Letter of Intent

Site Location - 4882 Sebring Dr. – Colorado Springs, CO 80911

Waiver Request – Administrative Relief.

# SITE PLAN

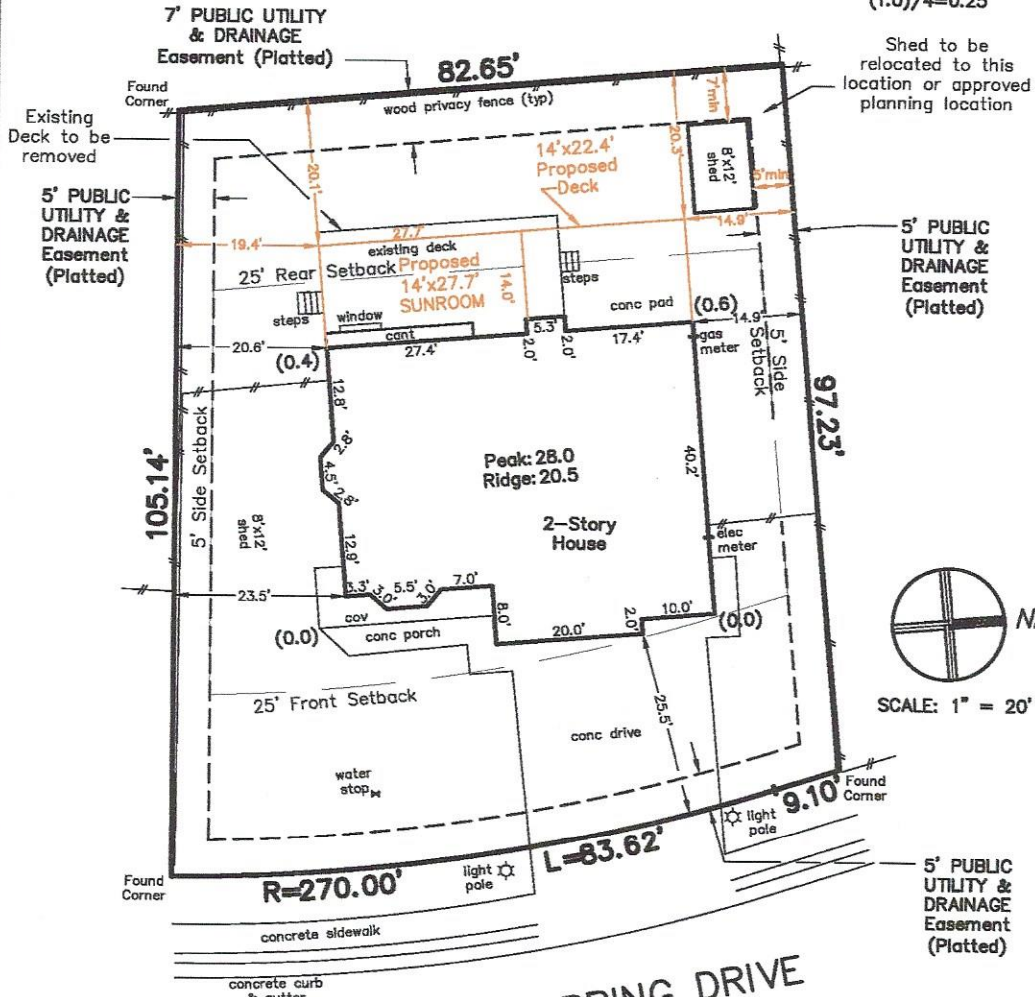
This is not adequate justification for an administrative relief request. You need to demonstrate compliance with the criteria listed in LDC Sec. 5.5.1(D). You are required to meet ALL of the criteria in 5.5.1(D)(1) and may also meet criteria in 5.5.1(D)(2). Please list the individual criteria and include an explanation of how this application meets the criteria.
